OUT21/11116

**McPhillamys Gold Project (SSD-9505)**

In our advice provided to you in June 2021 (OUT21/8080) we indicated that information on the volumetric implications resulting from an upgraded hydroline dataset would be provided separately. This further advice should be read in conjunction with our June advice, in particular NRAR advice on possible design modifications.

Mitchell Isaacs  
Chief Knowledge Officer  
**Department of Planning, Industry and Environment: Water**  
19 August 2021

Figure 3-1

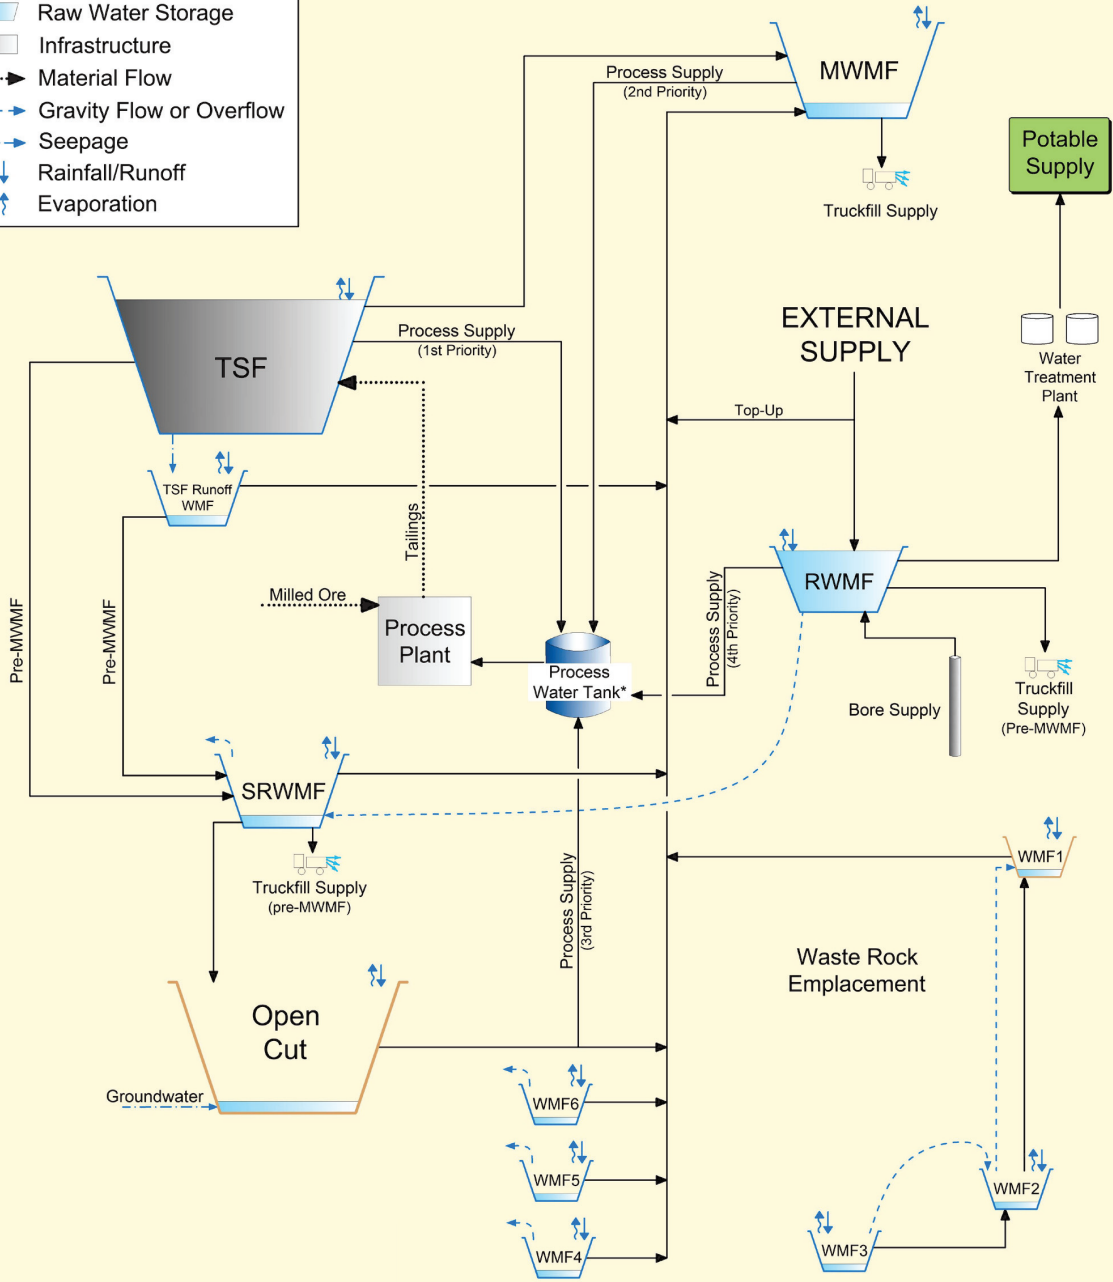
The storages which account for the majority of the water take (1758ML) are located on third or higher order streams based on the 2018 hydroline dataset. This includes the tailing storage facility (TSF) and two clean water dams CWF1(a and b). We acknowledge that CWF1(a and b) and also MWMF and RWMF would be on minor streams once the hydroline is updated but these dams do not meet the provisions in Schedule 1 (3 or 4) of the *Water Management (General) Regulation 2018* that would exempt the need for water licensing. The key aspects of the storages that require most of the entitlement are that:

- the proposed clean water diversion around the TSF does not effectively divert the fifth order watercourse it is located on, noting that there is still a significant volume of water captured, and the diversion removes a significant section of the river and replaces it with dams, pumps and pipelines, and
- the CWF1(a and b) dams capture clean water, and the primary purpose is considered to be to enable mining activity rather than for an environmental management purpose. Although this water is to be returned to the watercourse there is no ability at this time for these return flows to reduce entitlement requirements.
